# CITY OF ALBUQUERQUE

September 4, 2025

**RE: Notice of Violation**  
**Circle K**  
**9610 Eagle Ranch Rd NW**  
**Alb. NM 87114**

EROSION
CONTROL PLAN -
INITIAL

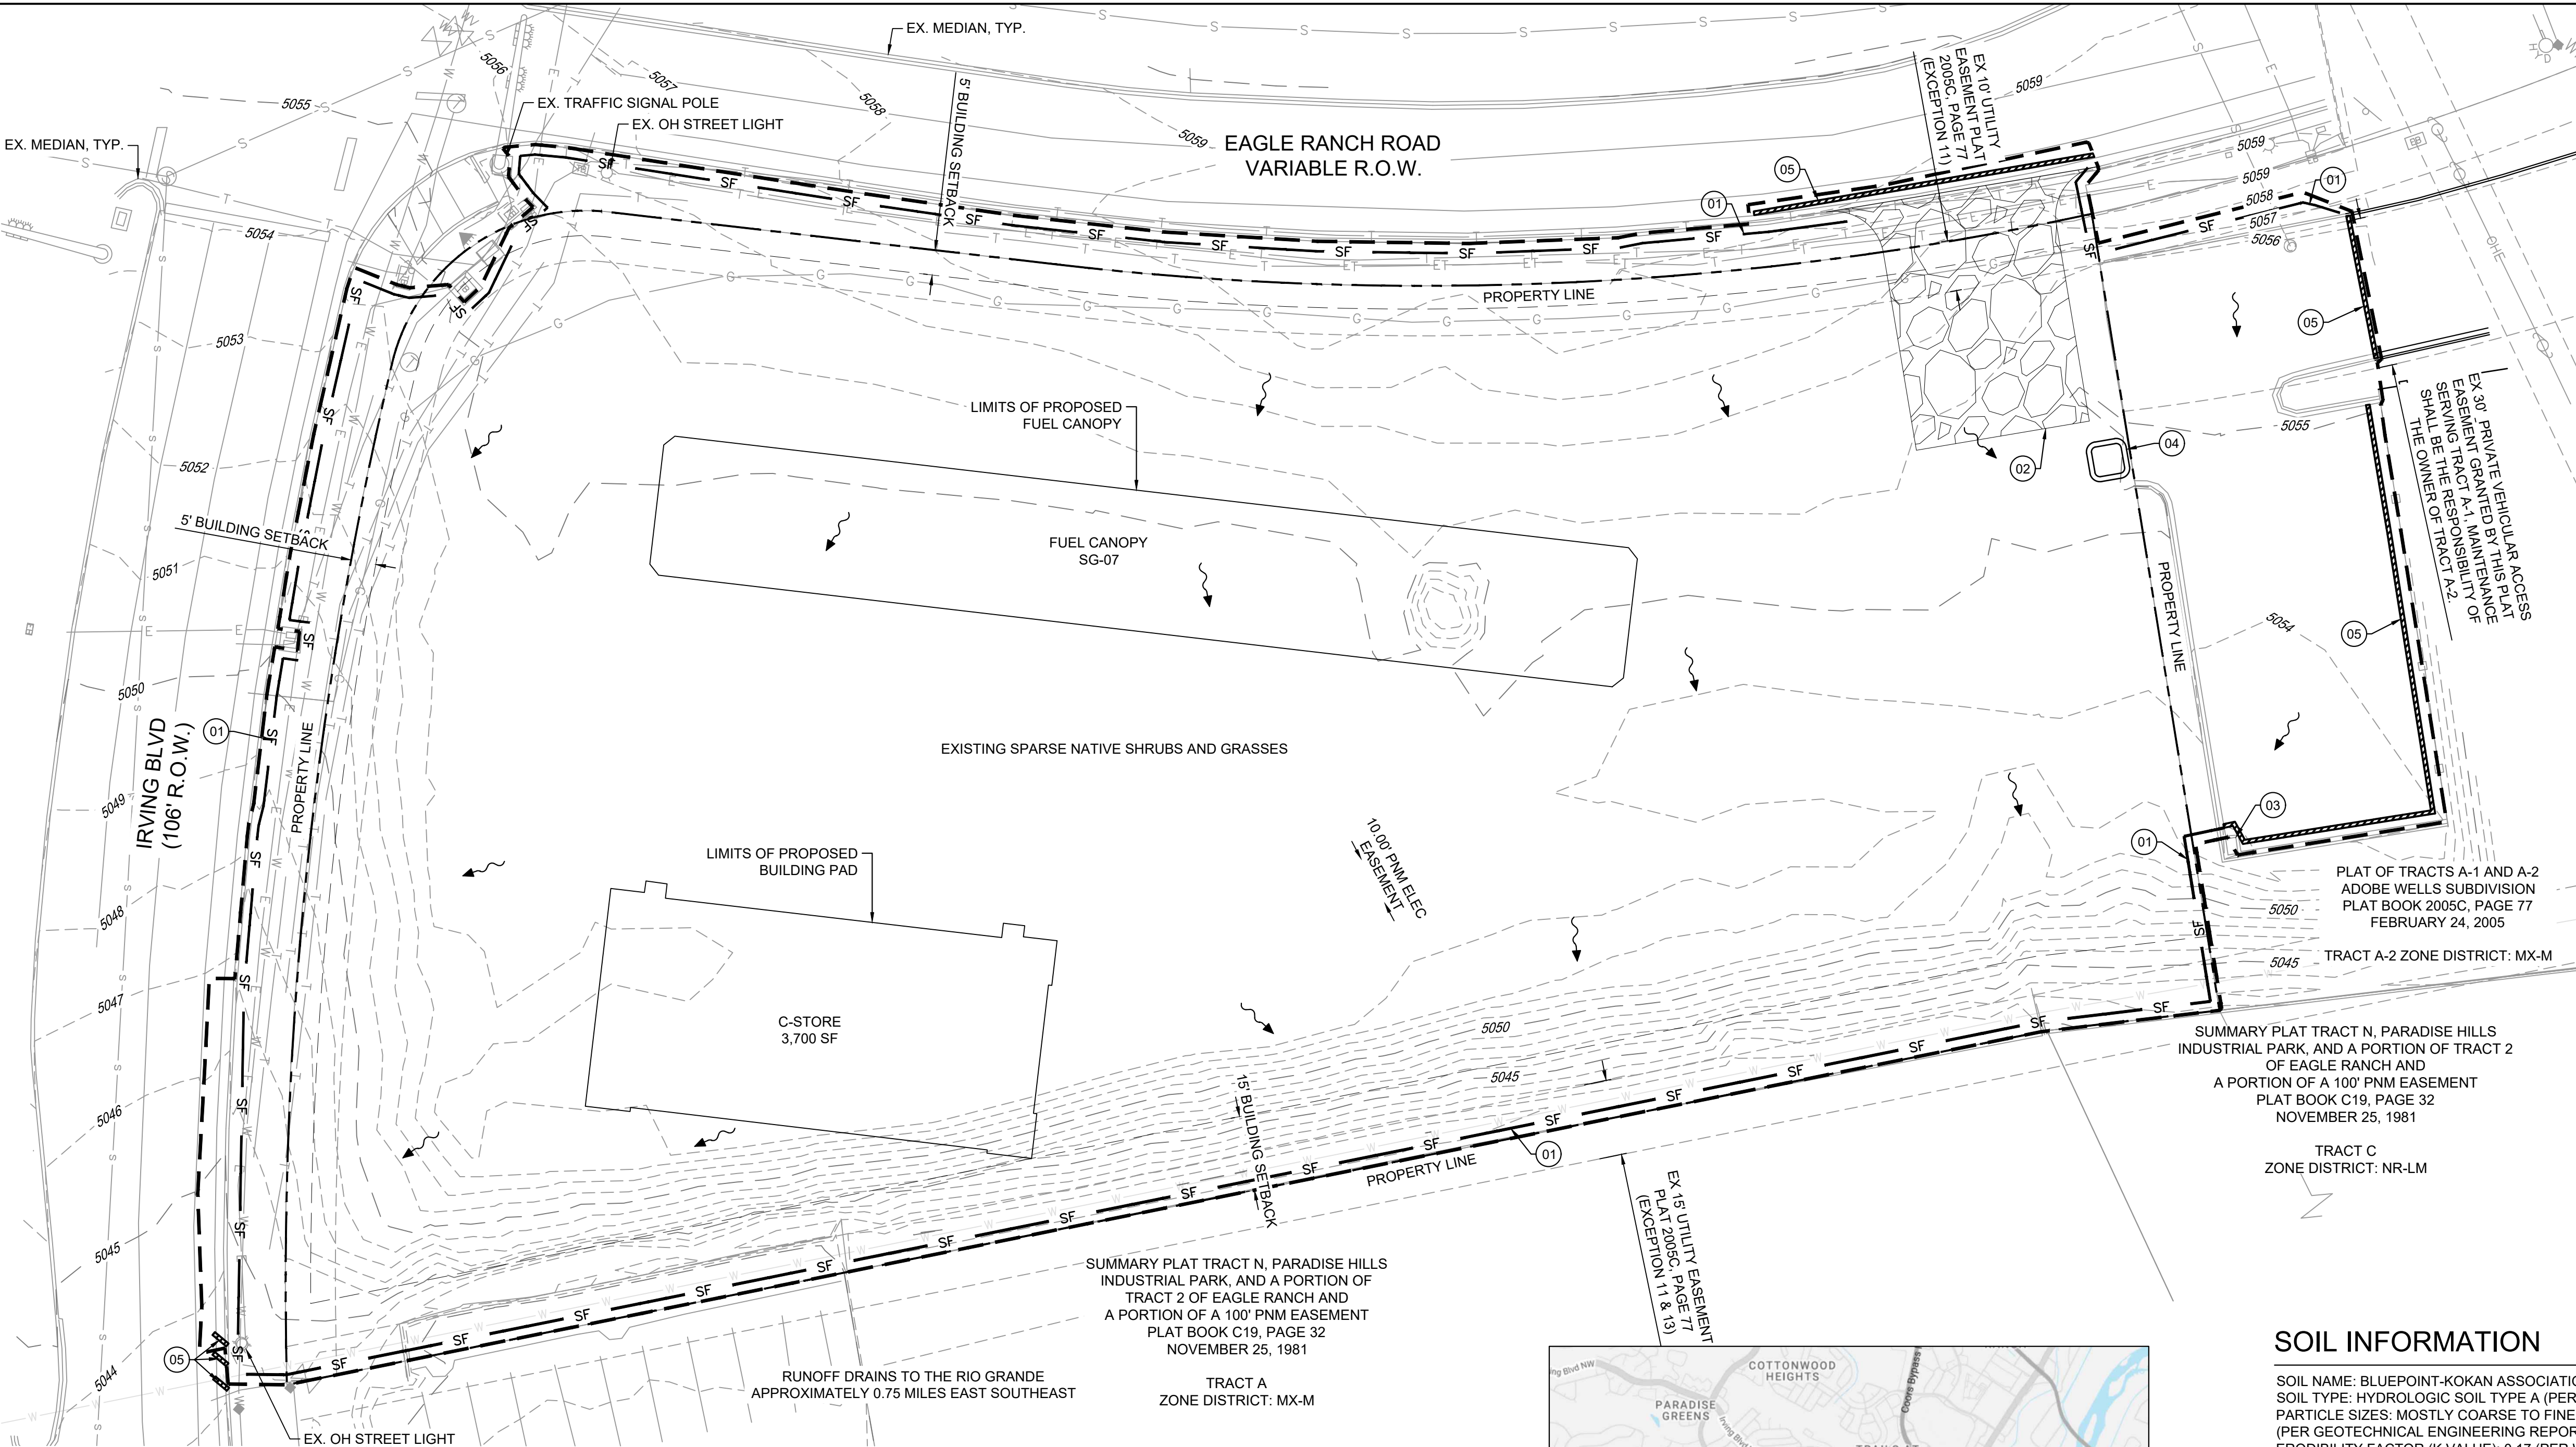
On 9/3/2025 a site visit was conducted and the erosion and sediment controls appear to be failing along the east property line of the site. The picture below shows that the runoff has already moved much of the gravel, exposed the filter fabric material, and now is allowing sediment to enter the properties to the east.

This Notice of Violation also serves as a formal Demand for Construction or Repair of the site's grading and drainage to eliminate the storm water runoff to the neighboring lots with a design and construction deadline of October 6, 2025.

Given that the site is experiencing failures in the erosion and sediment control systems that are now allowing stormwater and sediment flows across the property line, potentially causing damage to the neighboring lot to the east, this property is in violation of the Flood Hazard and Control Ordinance.
